4. **Project # 1002527**
03DRB-00373 Major-SiteDev Plan BldPermit

ABQ ENGINEERING INC agent(s) for CARLA GALLIPOLI request(s) the above action(s) for all or a portion of Lot(s) 18, Block(s) 16, **NORTH ALBUQUERQUE ACRES, TRACT A, UNIT B**, zoned SU-2 / IP, located on CARMEL AVE NE, between I-25 NE and SAN PEDRO NE containing approximately 1 acre(s). [REF: Z-87-42] (C-18)

CITY OF ALBUQUERQUE
PLANNING DEPARTMENT
DEVELOPMENT REVIEW BOARD

Project # 1002527

SHEET TITLE
SITE PLAN

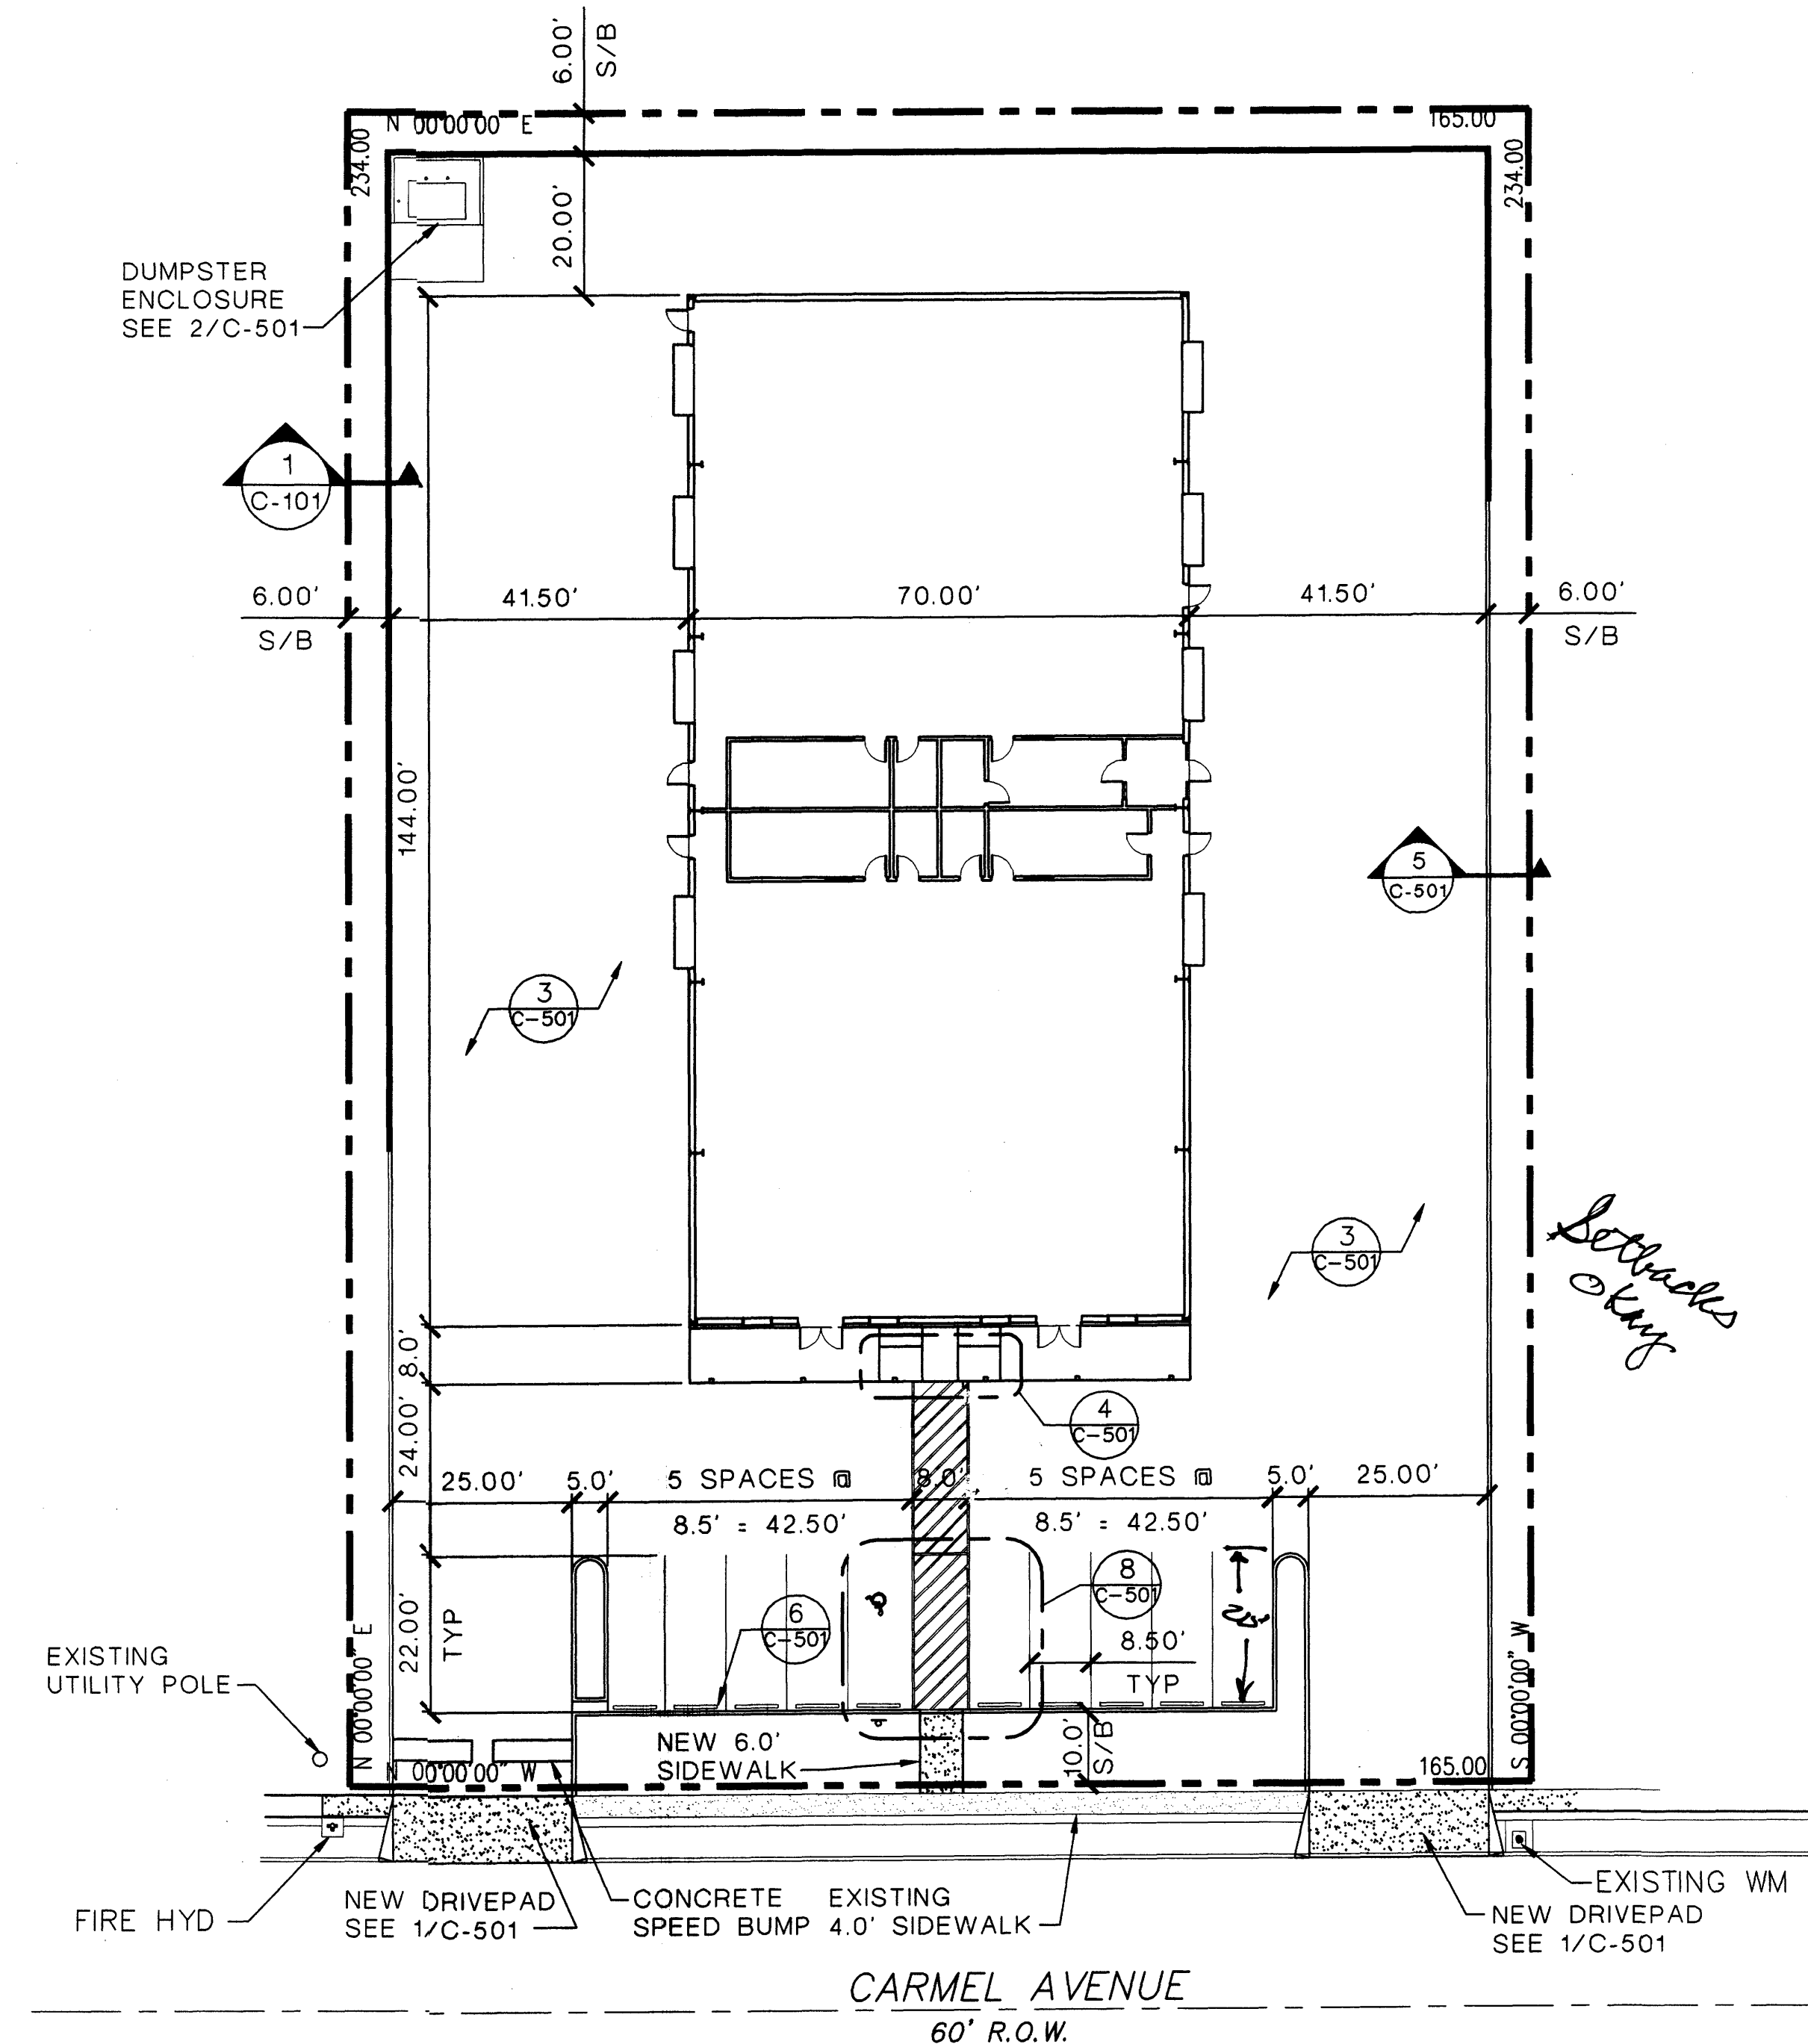
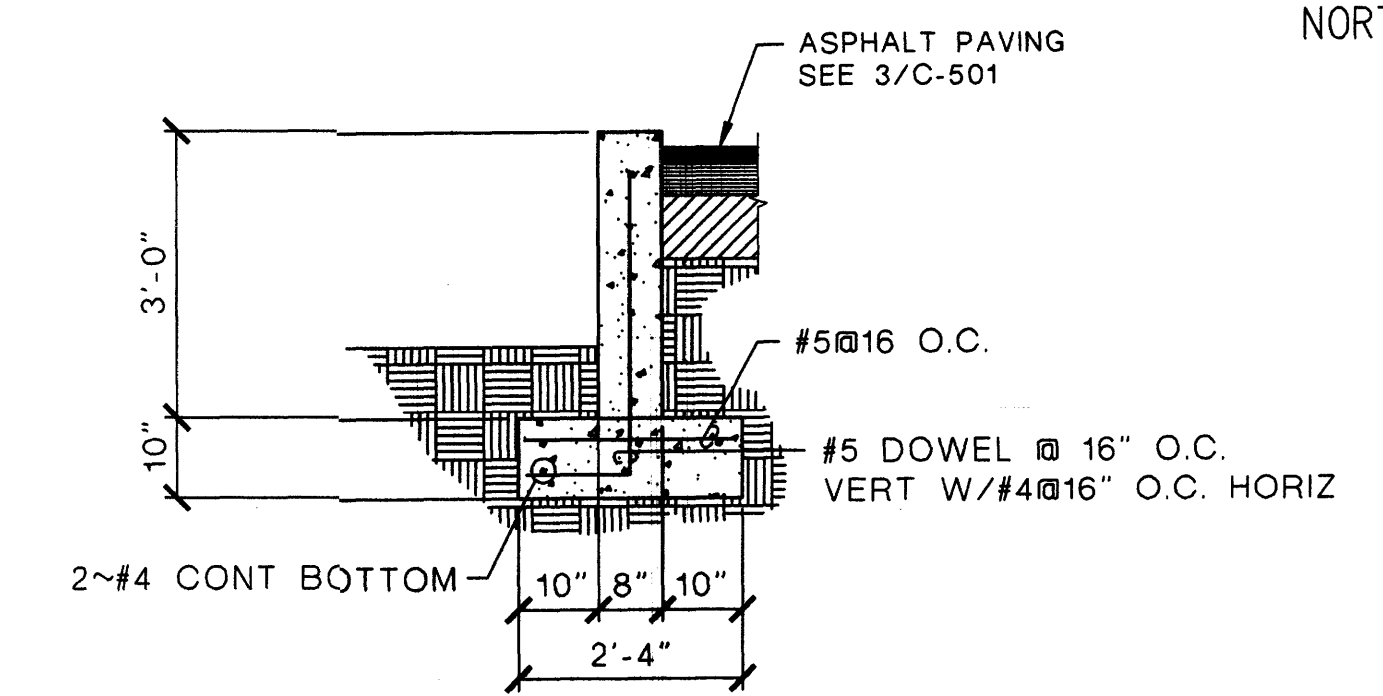
3. The updated signature block should be used. The Albuquerque /Bernalillo County Planning Division does not exist.
4. The setbacks listed on the site plan are incorrect for IP zoning. See Section 14-16-2-19(E) of the City Zoning Code. A 20' front yard setback is the requirement. The plan appears to propose 58'. A 10' side and rear yard setback is required. The plan appears to propose 29' for the rear yard and about 40' for the 2 side yards.

5. The 10' front landscape buffer requirement is met as are the 6' side and rear yard landscape buffers. However, Section 14-16-3-10 of the Zoning Code states that landscape areas must have a combination of trees, shrubs and vegetative ground cover. The rear & side yard setbacks show only native grasses. Page 54 of the North I25 Sector Plan also requires a mixture of trees, shrubs and vegetative ground cover.

Section 14-16-3-10 also requires the dimensions of the landscape buffer be shown on the site plan as well as the quantities, type and mature height & spread of each tree and shrub

In addition, the Special Screening Standards 1(b) of the North I25 Sector Plan require the loading and unloading of commercial vehicles be set back from all property lines to reduce visual impact. Inclusion of shrubs & trees in the rear & side yard landscape buffers would fulfill that requirement. However, be aware that trees can not be planted above a water line. So that section of the east side landscape buffer would only have trees behind where the water line curves into the building.

SOUTH ELEVATION

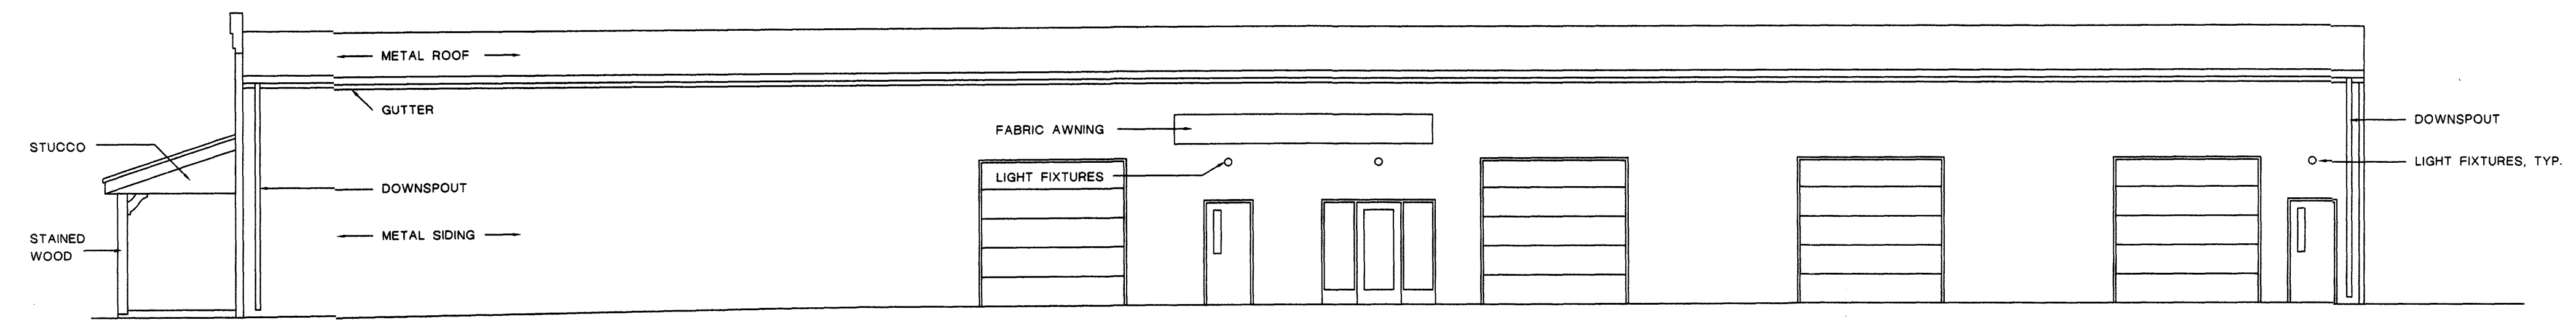
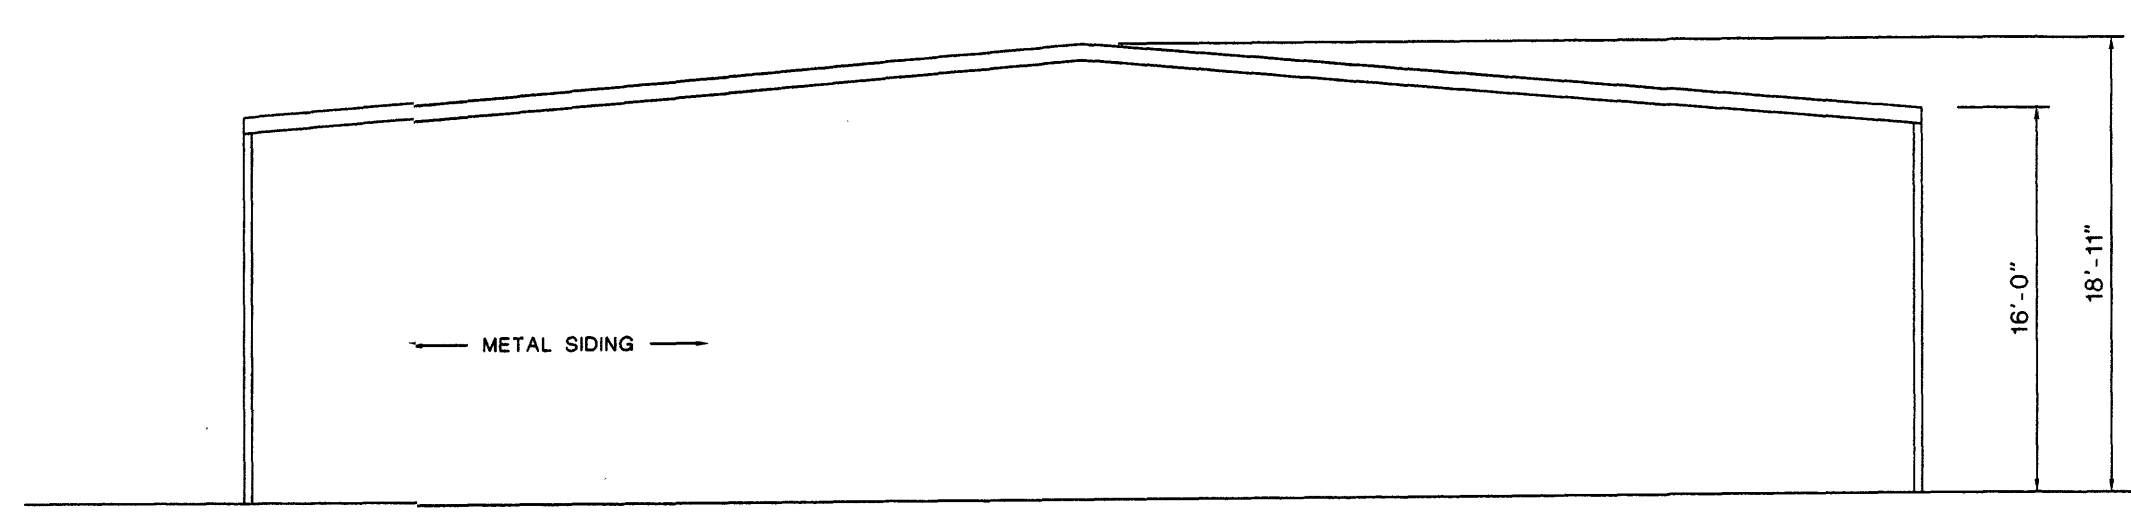
6. The Elevations Sheet is missing the West Elevation.

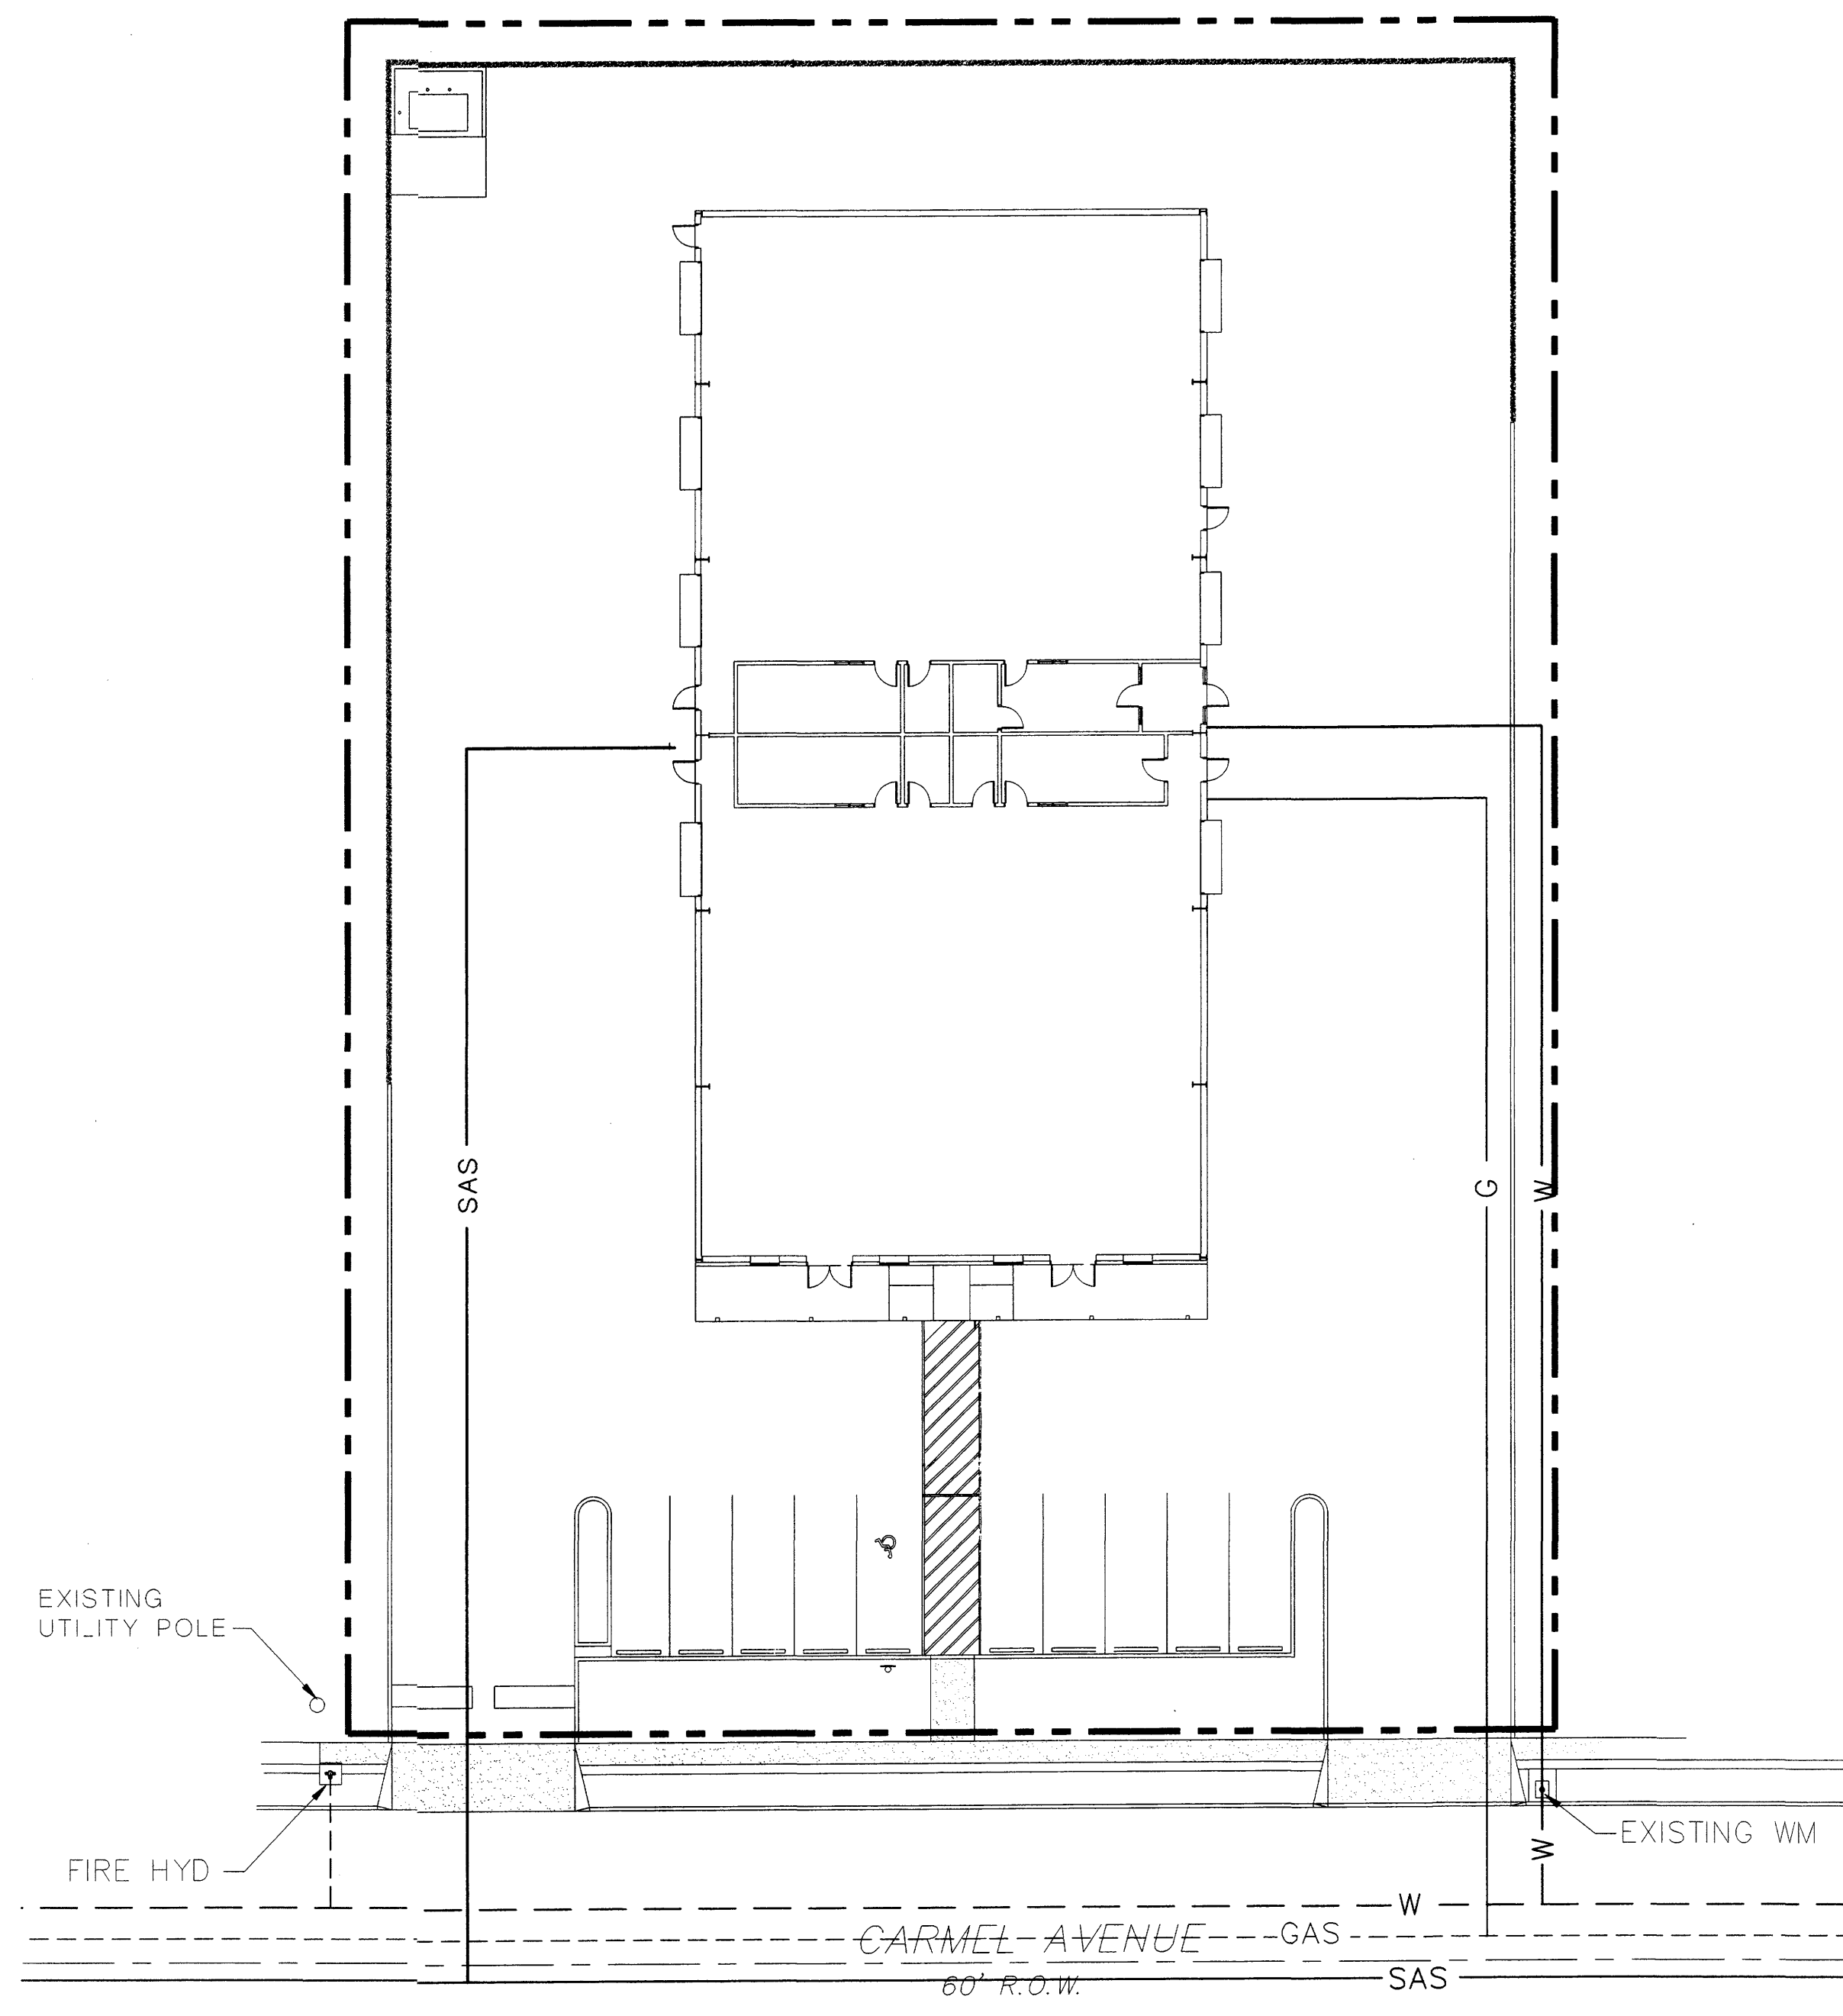
Fire Department **THIS PROJECT REQUIRES 3 FIRE HYDRANTS WITHIN 450 FEET AS THE TRACK ROLLS. PLEASE VERIFY LOCATIONS. DISAPPROVED, PER RAY SANCHEZ AFD.**

Need copy of Fire Flow calculation sheet showing required GPM.
